Info Only: Engineering comments
are in blue.

7280 N. Nevada Lane

Drainage letter

EL PASO COUNTY PROJECT # - PPR-2411

PROPOSED DRAINAGE MAP

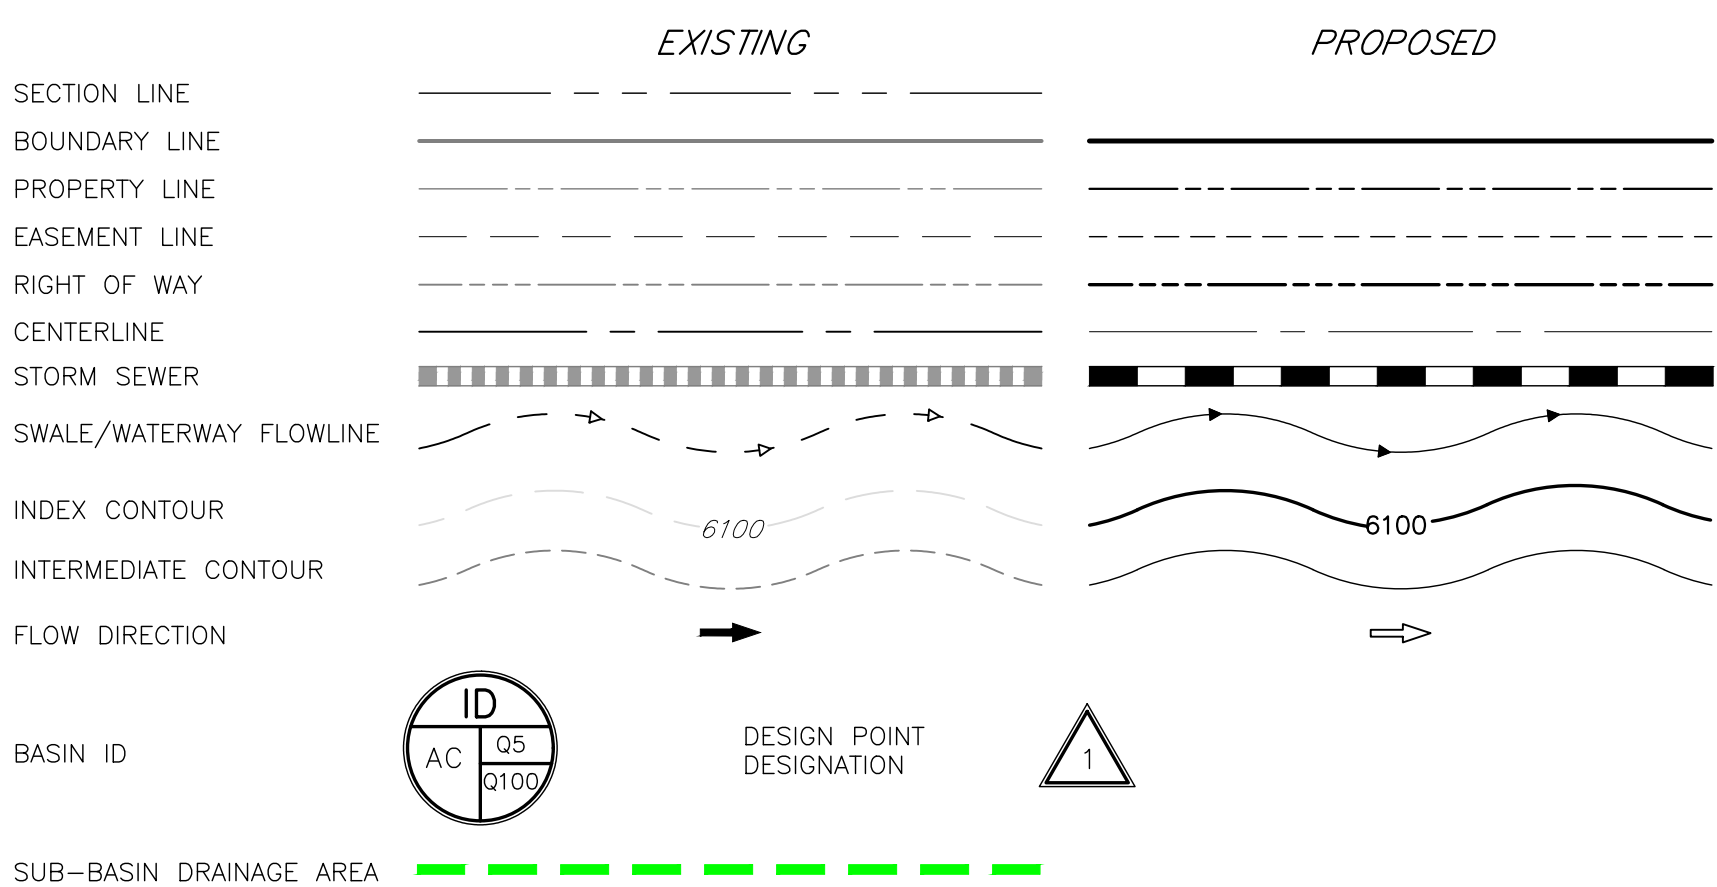
Please include historical map showings
these historical sub-basins.

Flows leaving the site at DP5 are concentrated. How can erosion on California Drive, a gravel roadway, be mitigated?

This statement cannot be verified until the historical drainage map is provided. Additionally, the runoff flow leaving the site at the proposed discharge point is significantly higher than the historical flow. Therefore, a detention facility is required to manage the increase.
